Application No: A/253/21/OUT
Site Address: Land between 32 Downs Way and 2 Ambersham Crescent Angmering BN16 1AB
Description of works: Outline planning application with all matters reserved for the erection of 1 No bungalow dwelling with off street parking and private amenity space.

Thank you for your internet representation made on 24th January 2022 which has been recorded as an objection with the comments as follows:

Roof Plan 1:50

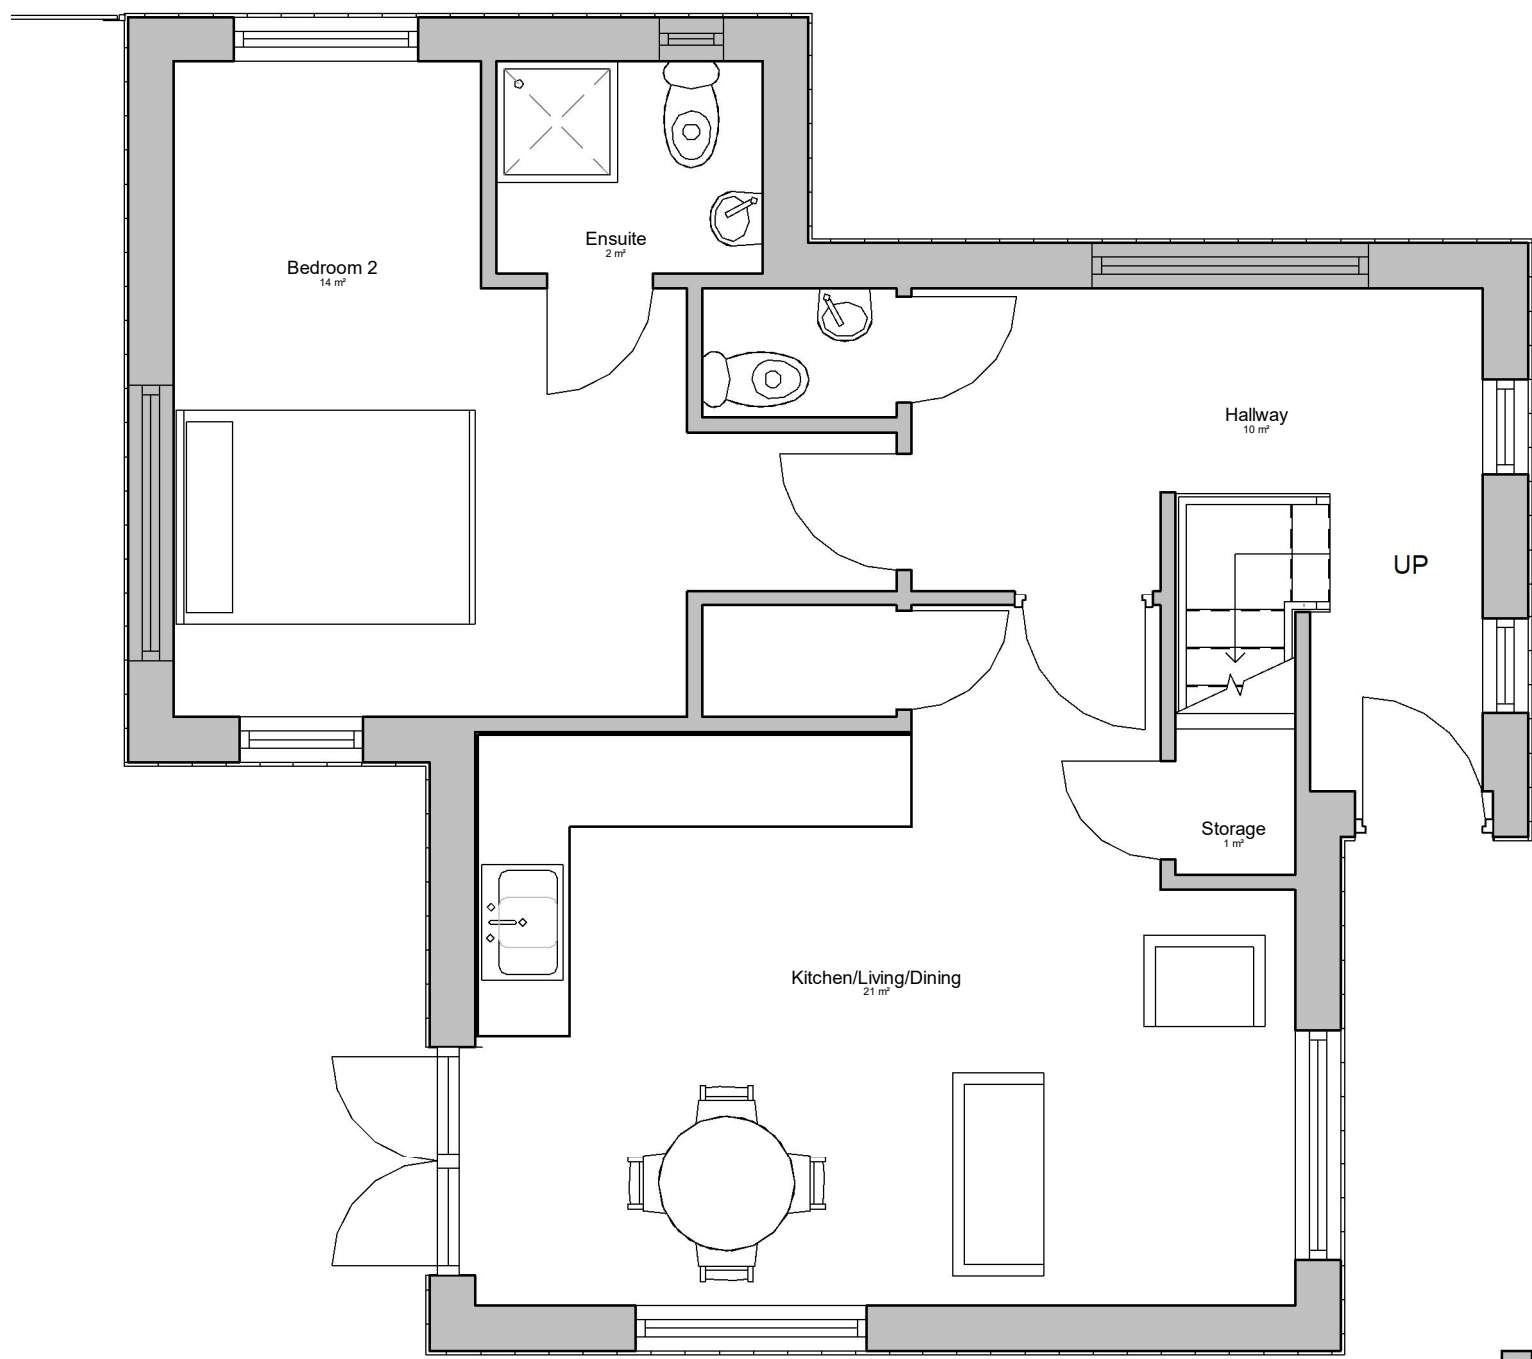
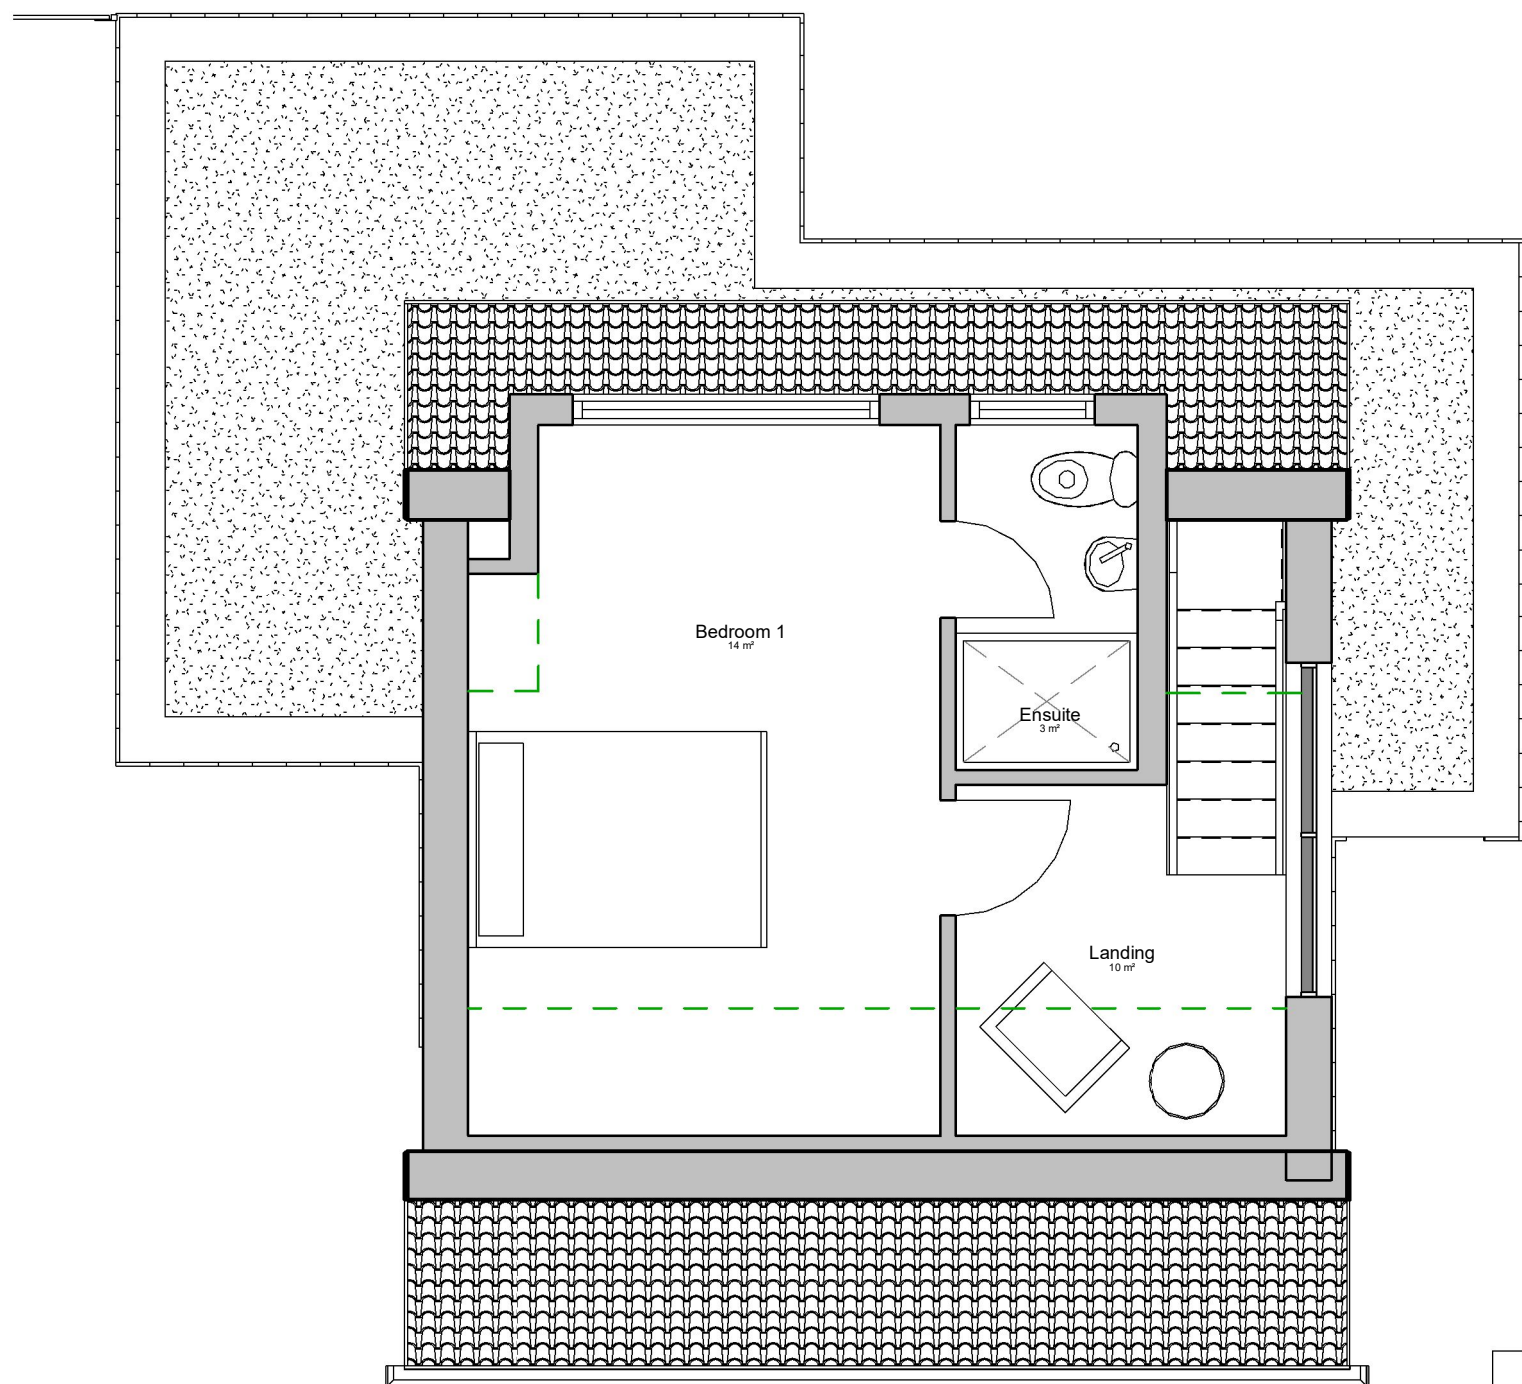
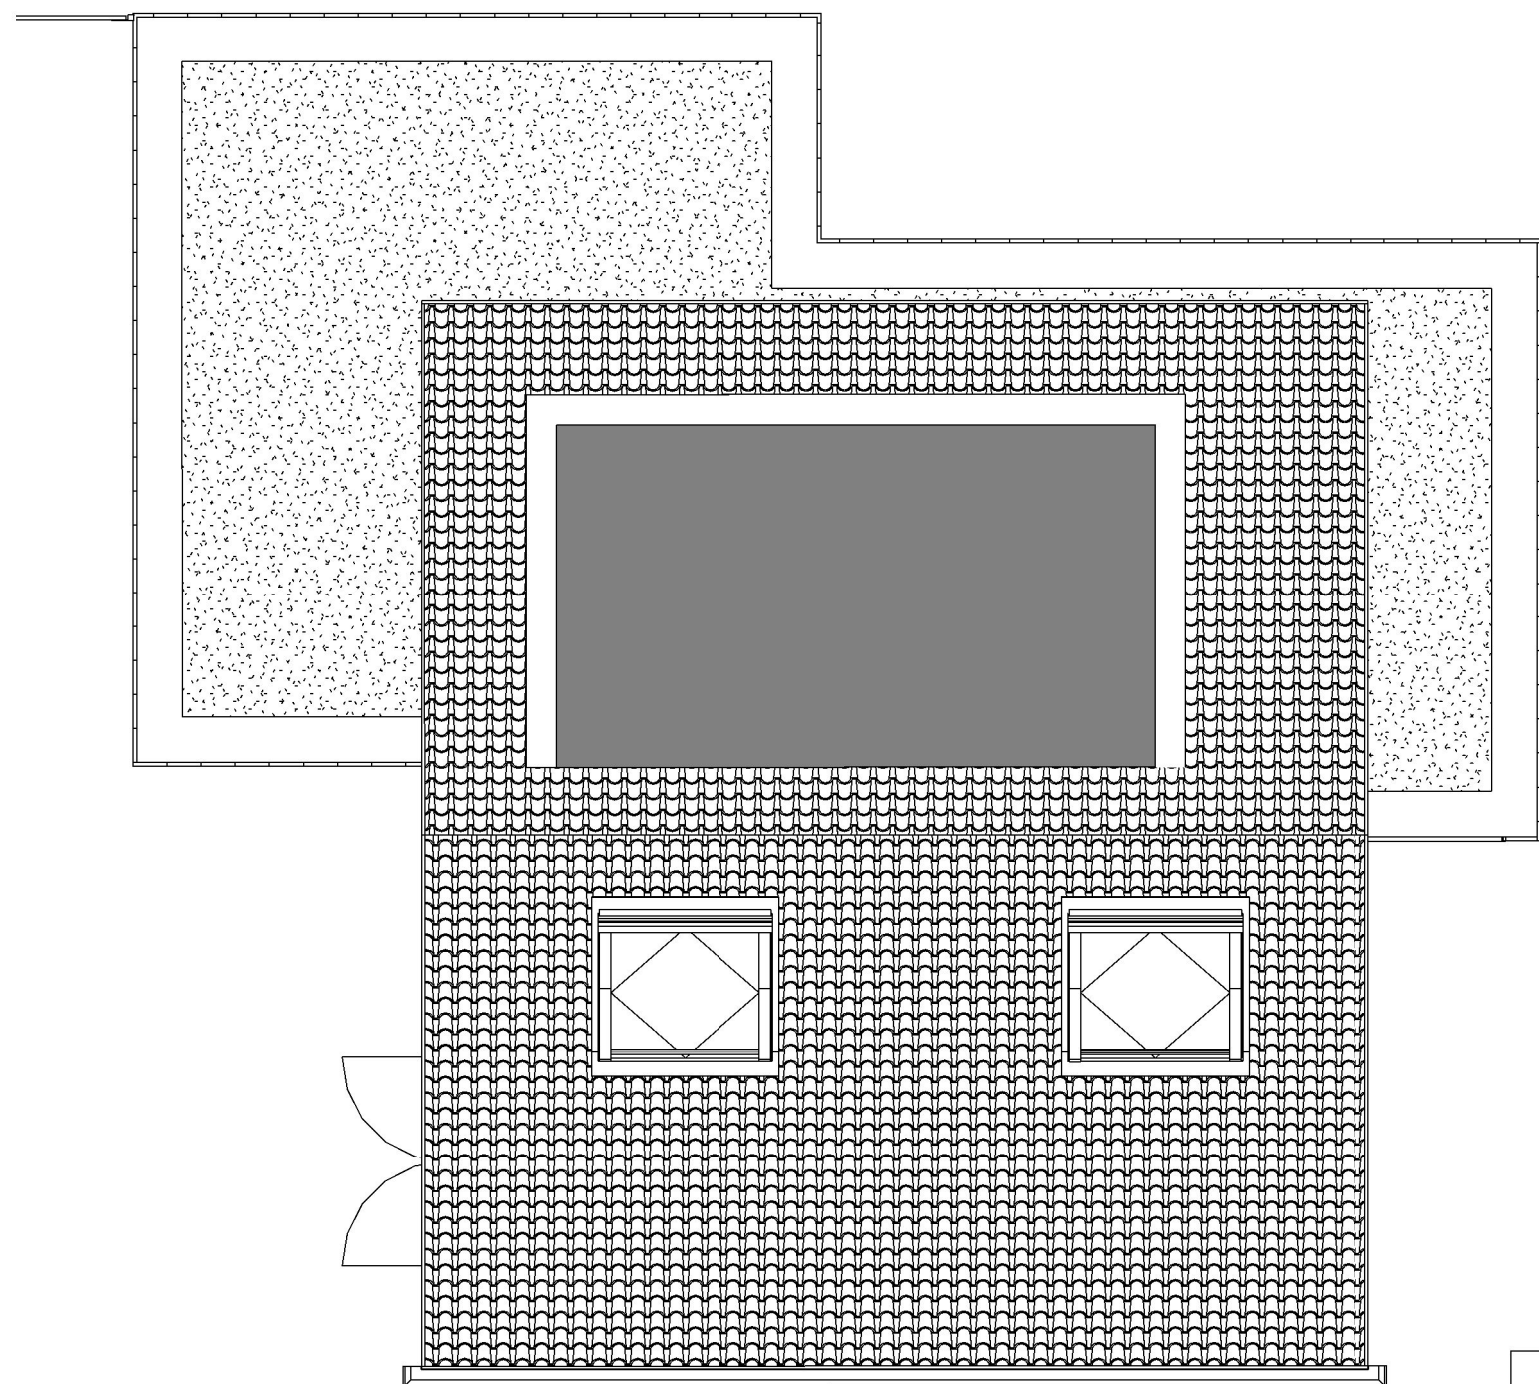
8. Skylights to the rear of the dwelling directly overlook the dwelling at 2 Ambersham Cres.
9. The green space was created within the Downsway/Ambersham Cres development, solely for that reason - Green space. However, the ADC seem to have an agenda to allow building on anything remotely looking like a possible building site.

Indicative Plans and Elevations

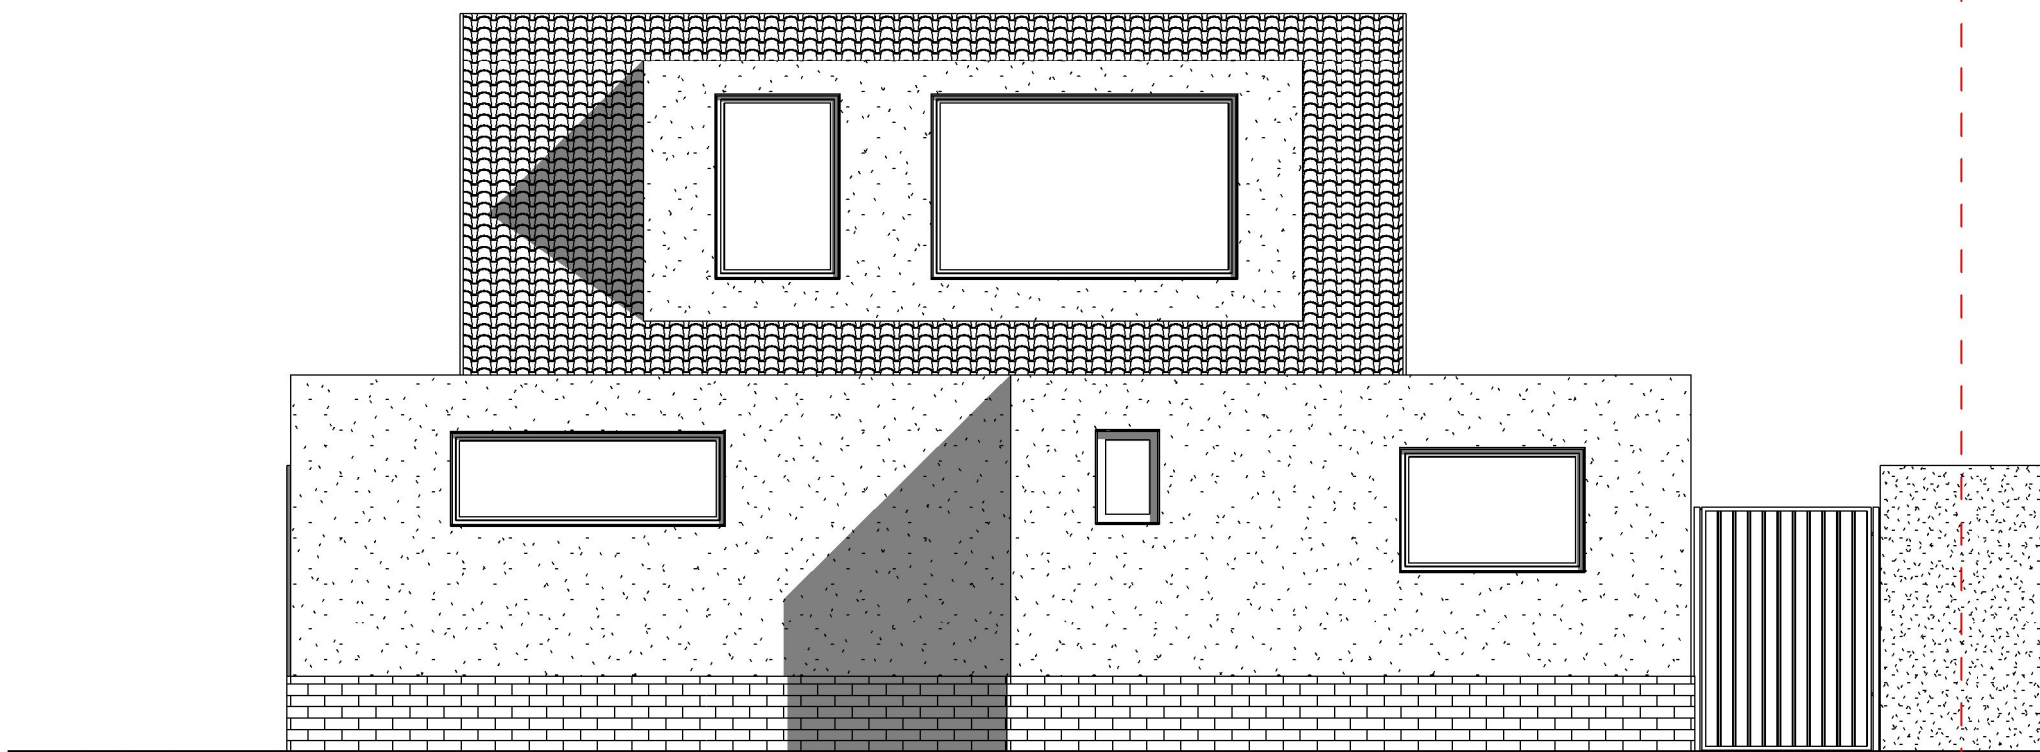
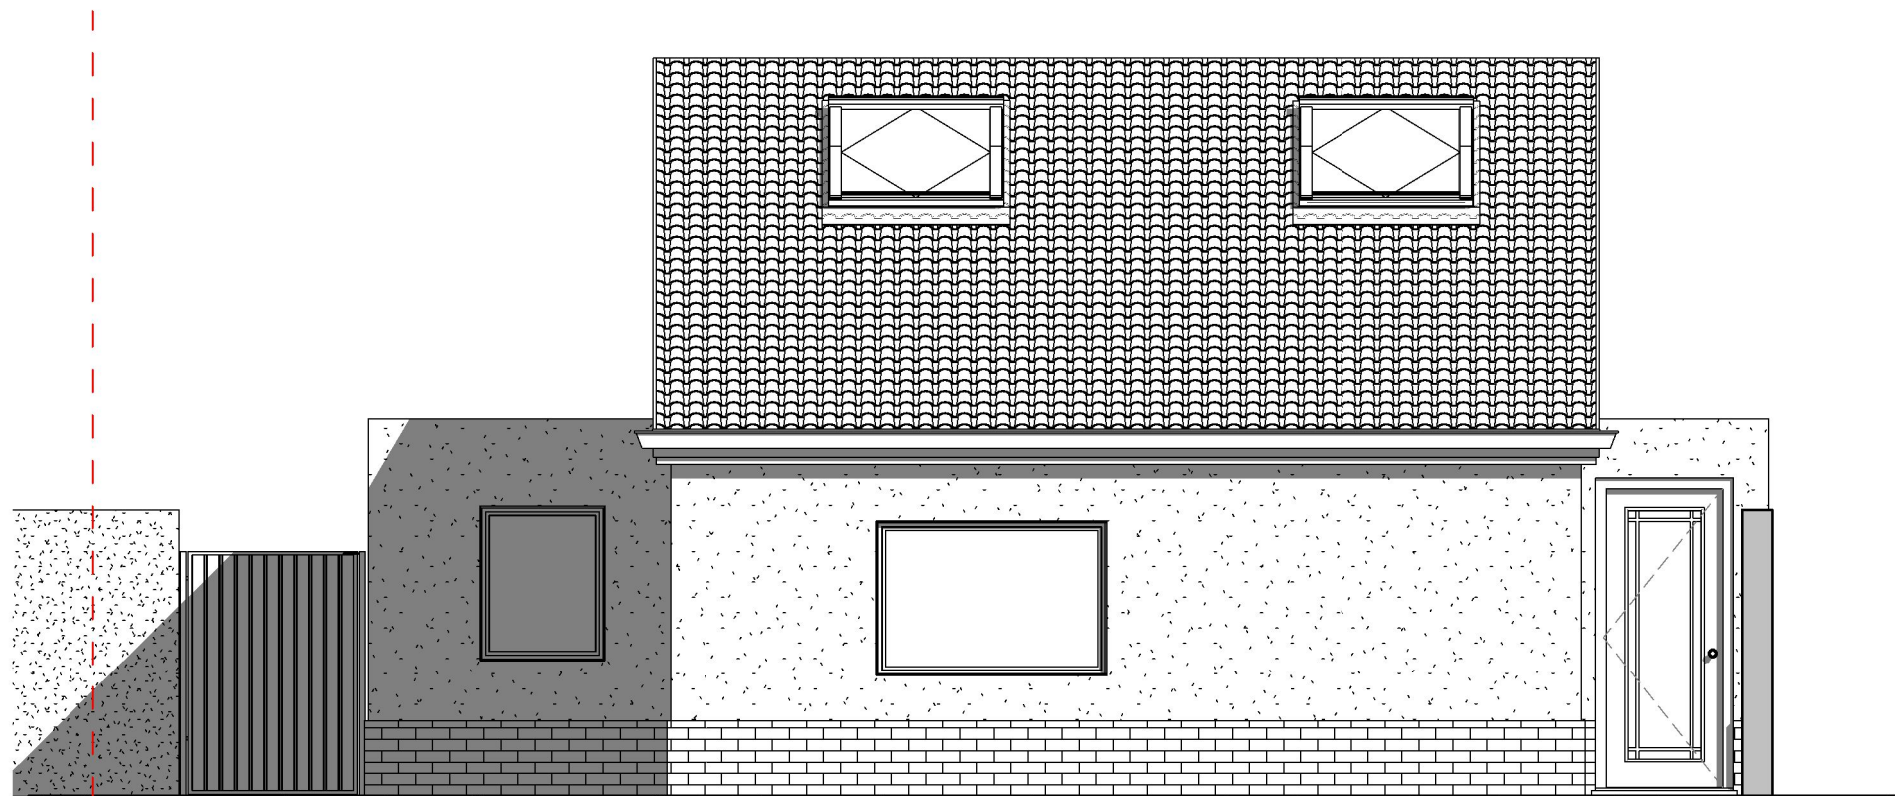
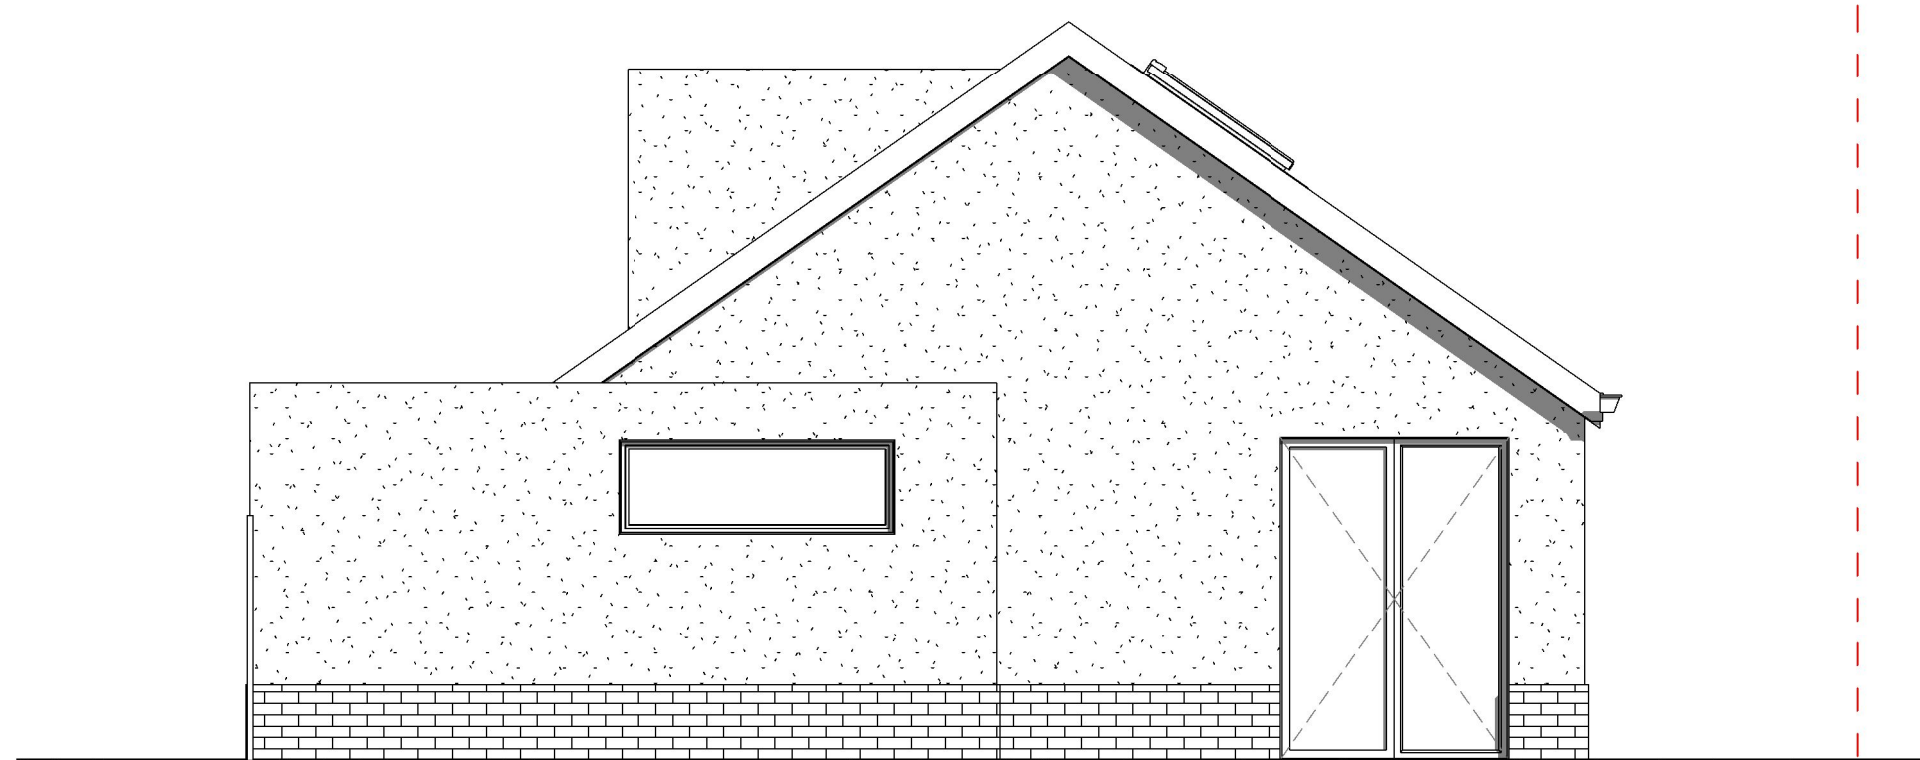
6. The flat roofline to the front of the dwelling is out of keeping with all other dwelling in the area, and not permitted on any other dwellings. If this was to be approved, it would set a precedent for other homes owners to do the same. Again out of character
